Development Management
Lincolnshire County Council
County Offices
Newland
Lincoln LN1 1YL
Tel: 01522 782070
developmentmanagement@lincolnshire.gov.uk

Application Ref: H23-0313-25

Proposal: **Provision of new poultry unit & associated works**

Location: **Land at Peartree Hill Road, Whaplode Drove, Spalding**

Figure 3 – Modelled Arrangement

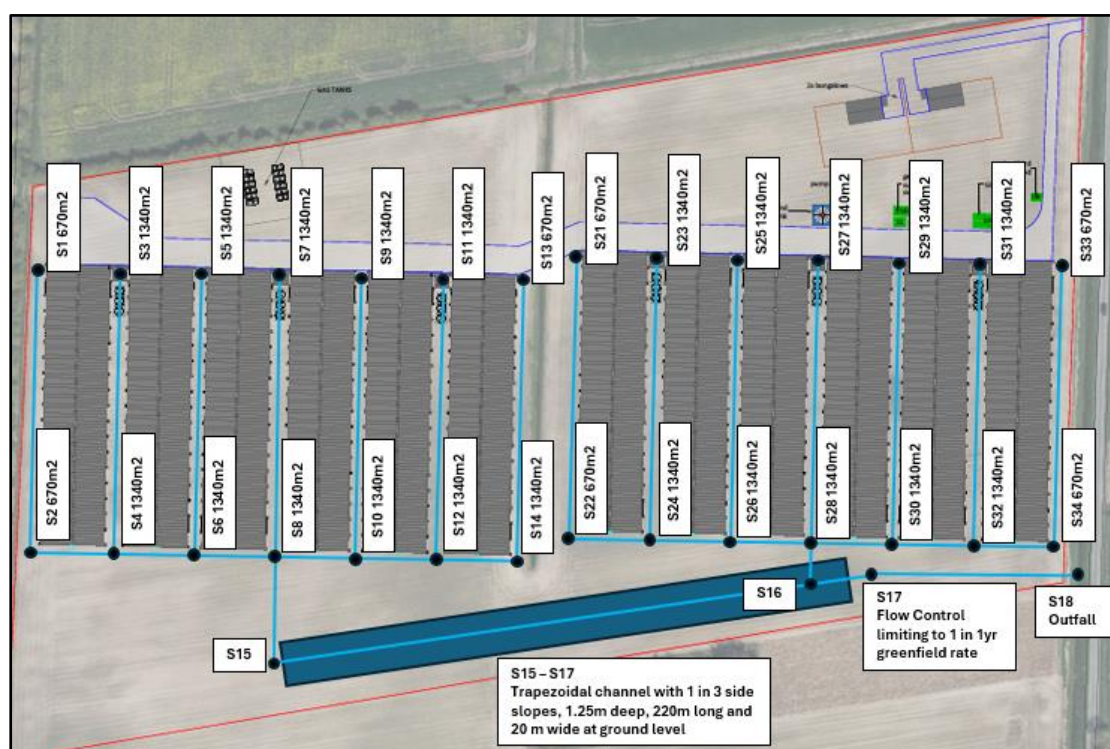
The applicant is showing that they wish to discharge surface water to a watercourse at a rate of 11.2 l/s. The contributing impermeable area is less than 9.2ha and therefore, the proposed discharge rate is in excess of greenfield rate for the impermeable area only. The rate should be reduced to as near to the greenfield rate as possible for the impermeable area.
